Re: Application number 2020/91186

Land at Westcroft, Honley Holmfirth - Reserved matters application for erection of 24 dwellings pursuant to outline permission no.2018/91198 for residential development.

PLOTS 06 - 08
PLANS & ELEVATIONS

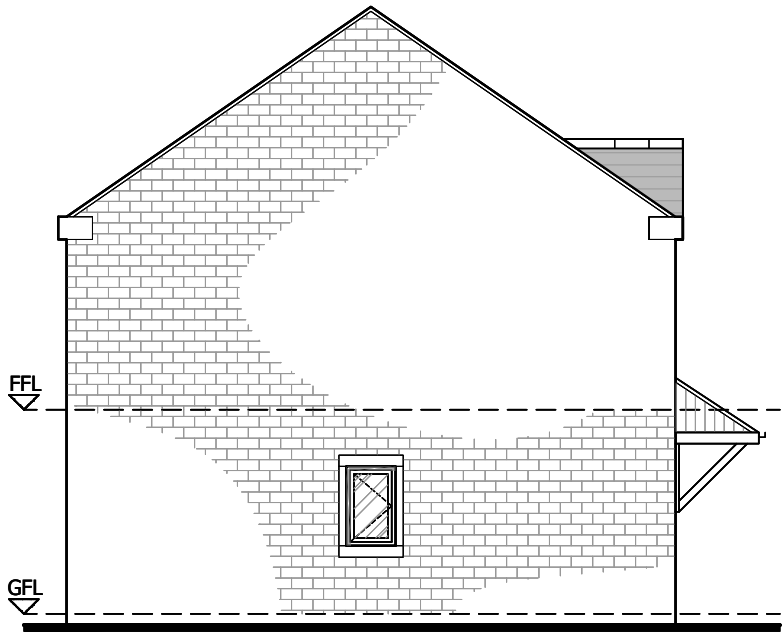
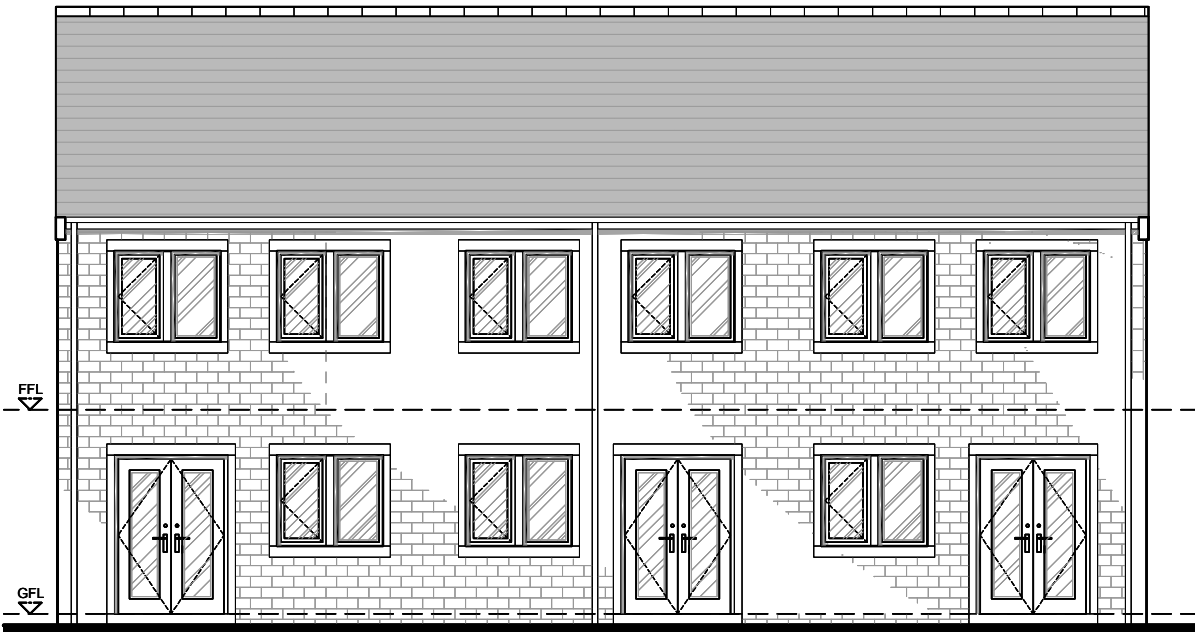
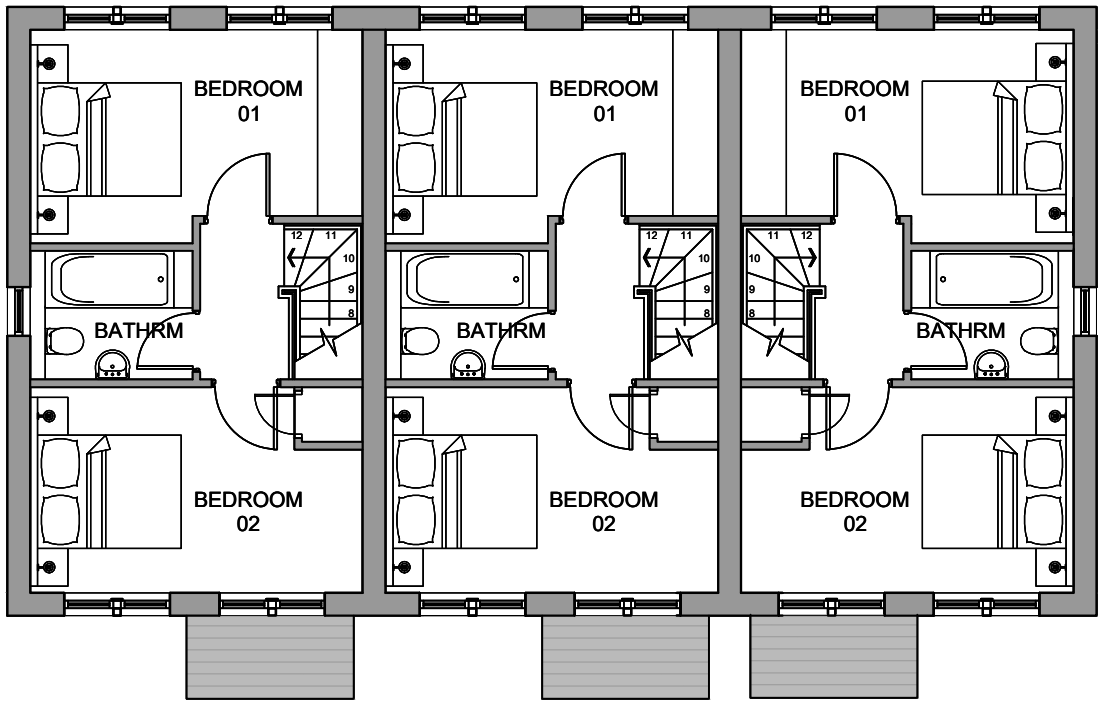
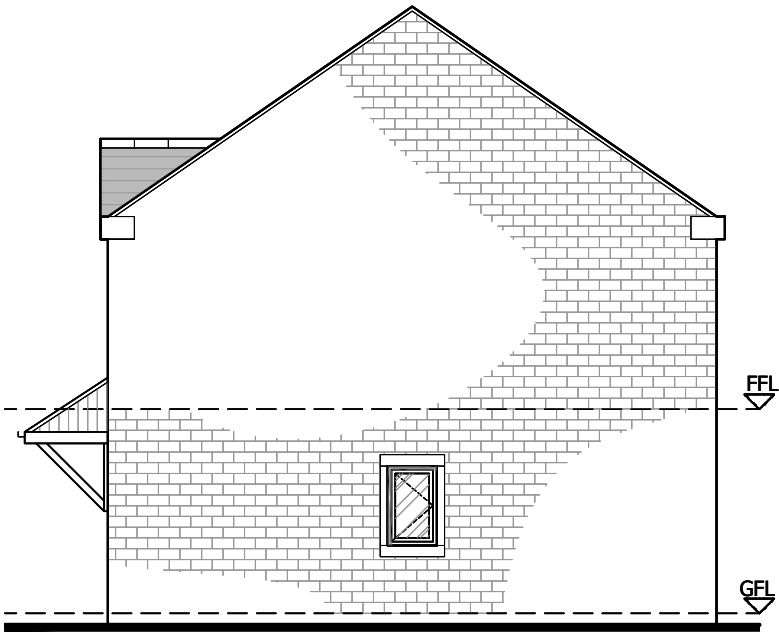
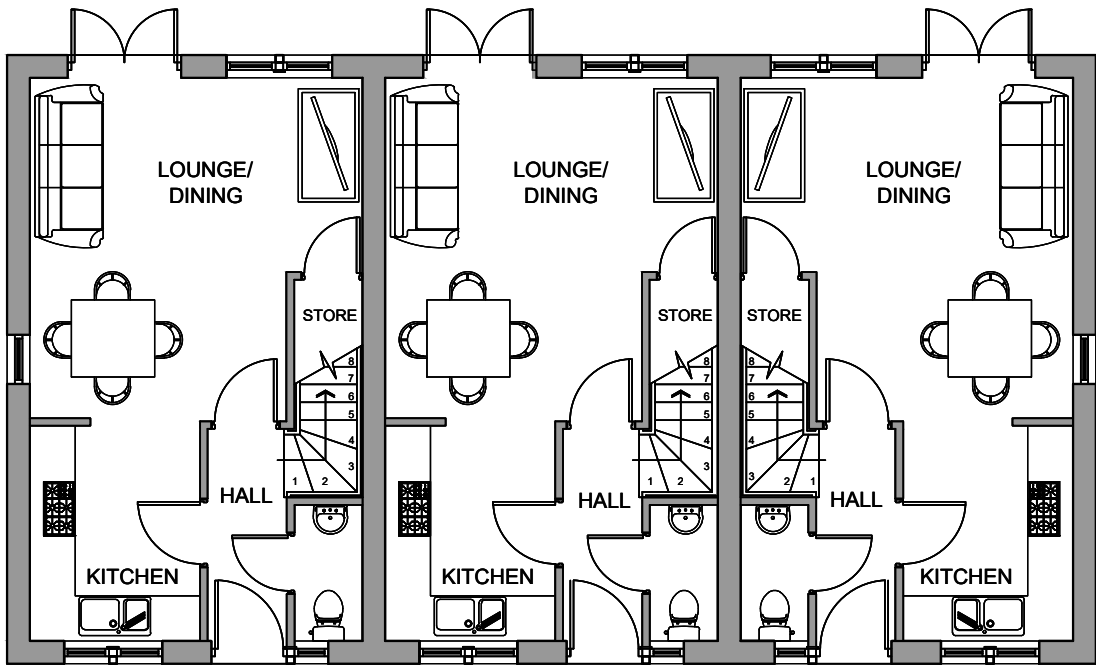
- Disappointing to see 3 storey houses - not in character with the surrounding 2 storey houses. Potential to reduce good natural daylight levels to the wellbeing of existing residents. Same layout but with only 2 storey houses would fit in better.
